From: Martyn White
Sent: 22 February 2019 09:19
To: Planning.Responses
Cc: Anita Gardner
Subject: CM/38/18/PL

CM/38/18/PL

The application relates to the retention of 5 temporary storage containers for ancillary storage. It is noted that the containers are required for the duration of the building works on the site. Once all of the relevant consents have been sought, and the works implemented, the storage containers will no longer be required and should be removed.

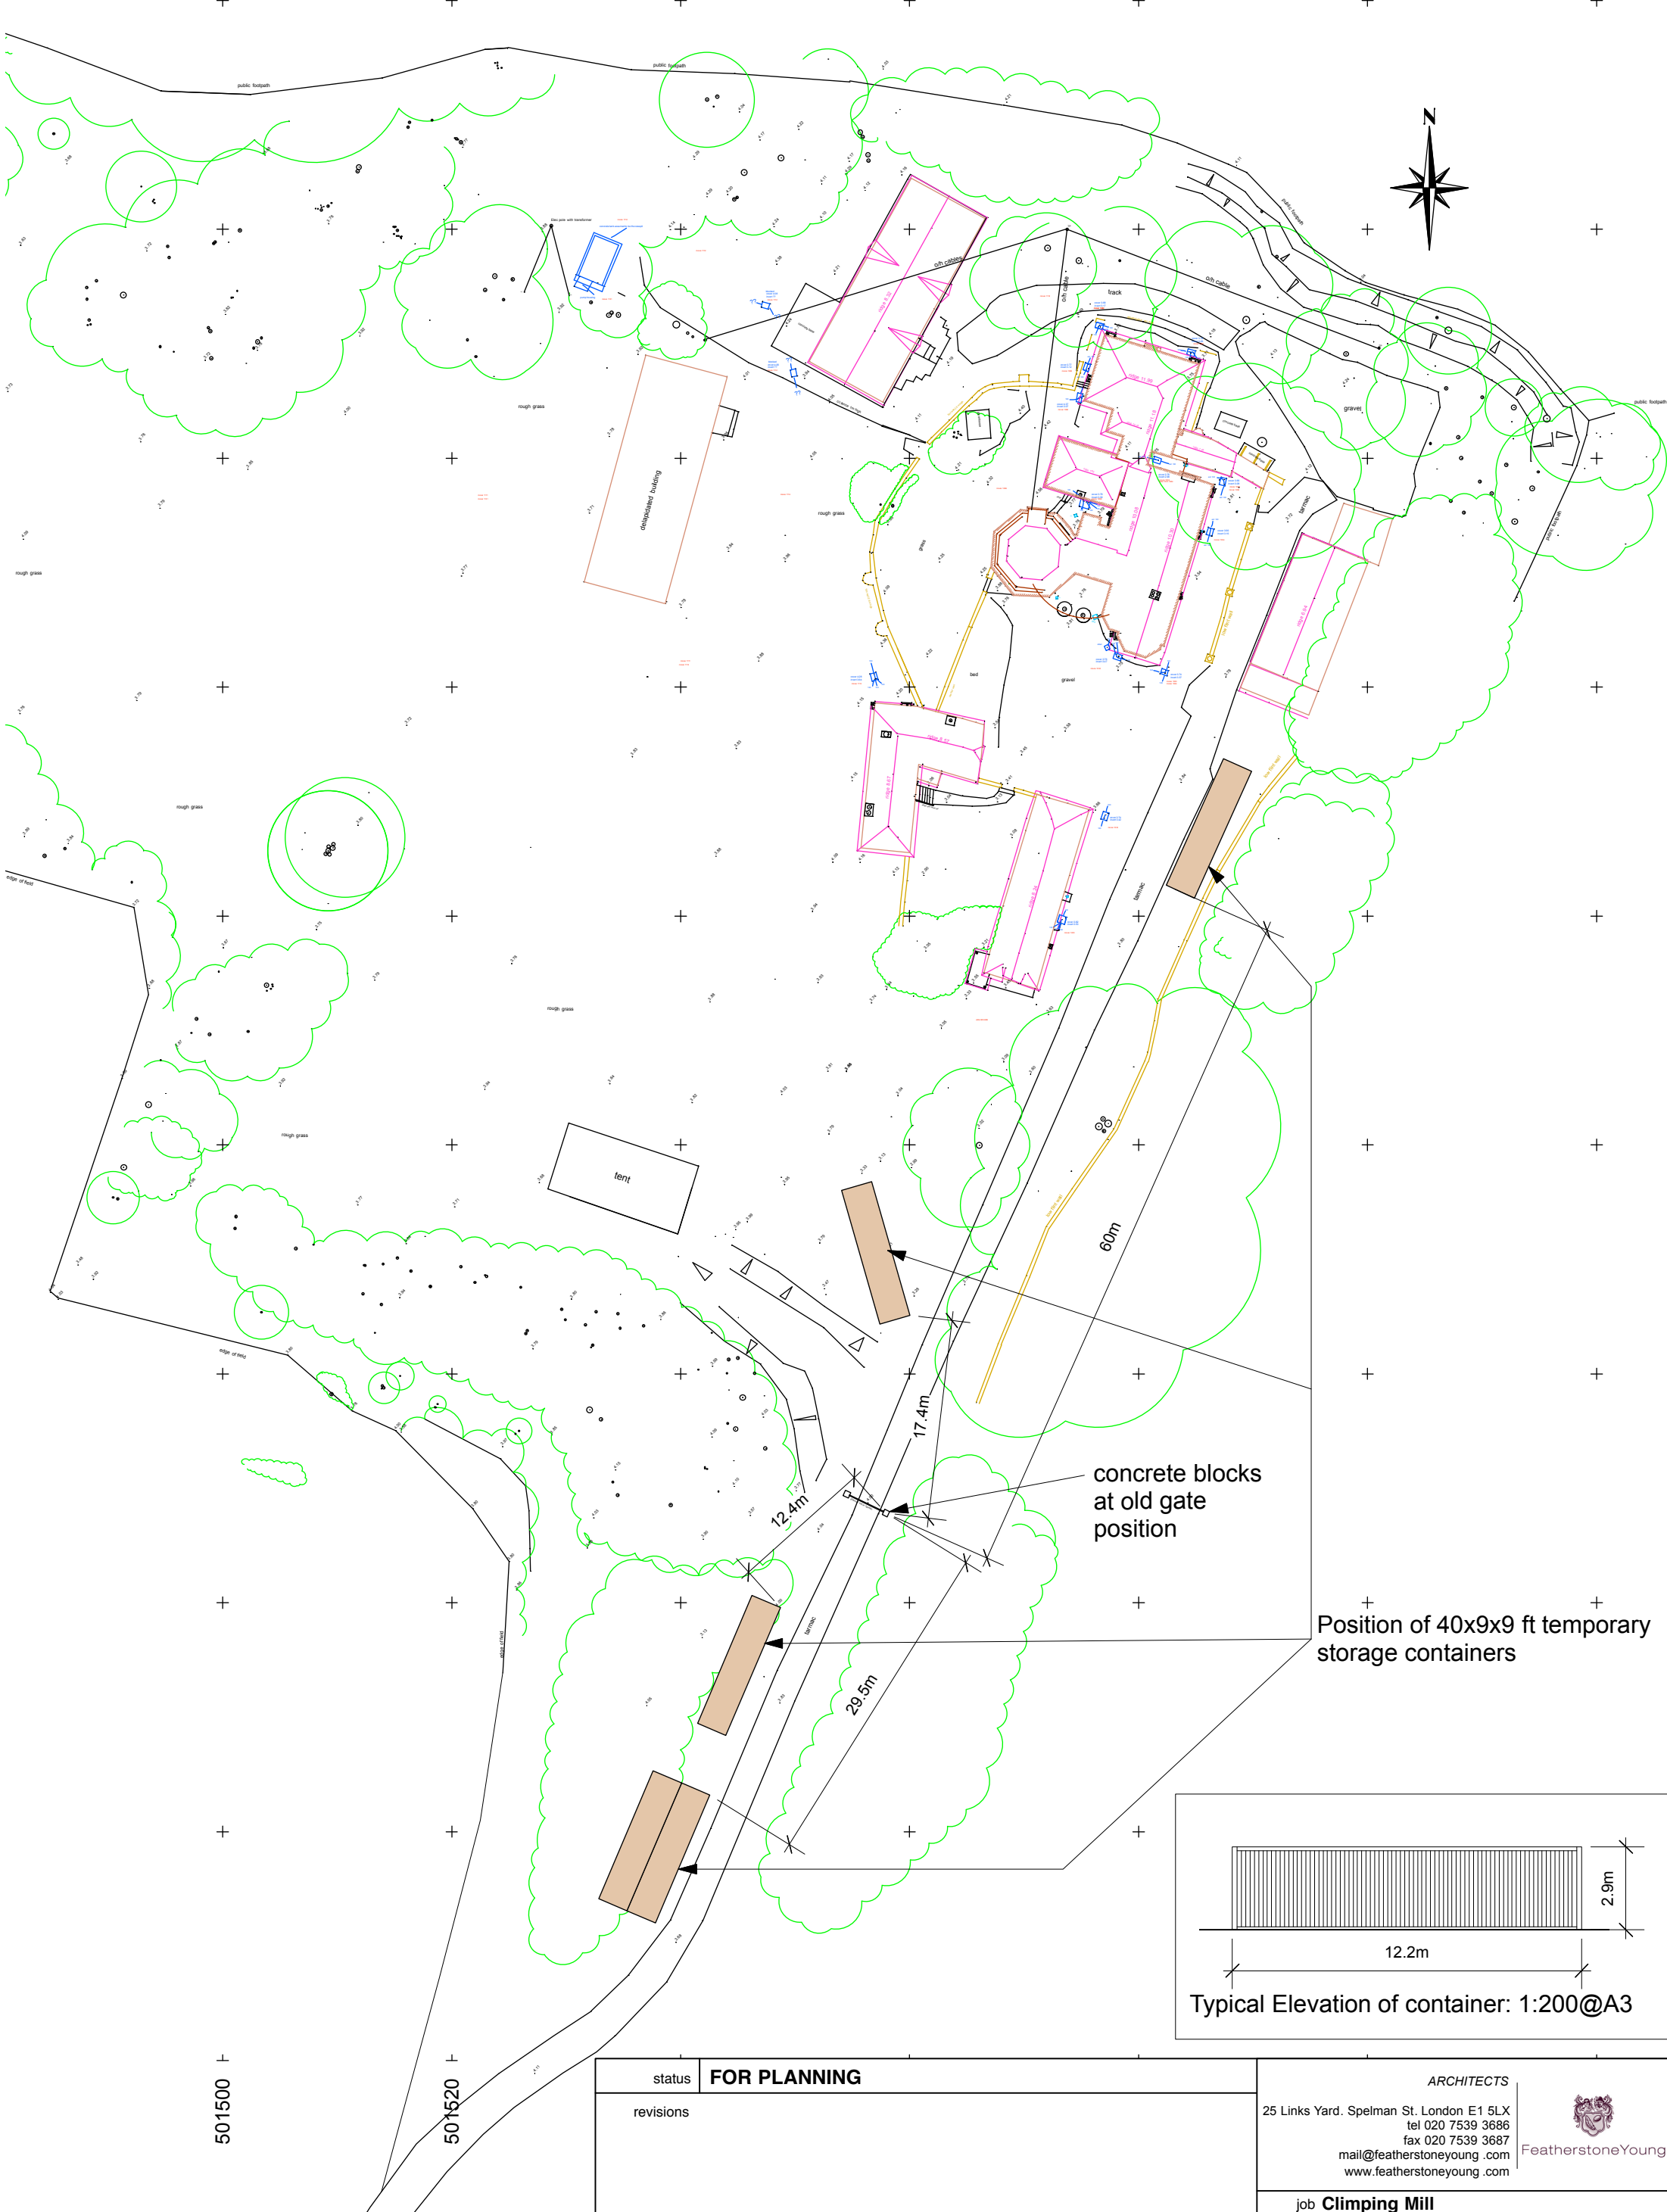
It is considered that the retention of the containers is acceptable as they will not form a permanent feature within the grounds of the listed building. As a consequence, there is no objection from a conservation perspective.

It is suggested that a suitable/realistic timeframe for the retention of the containers is approved.
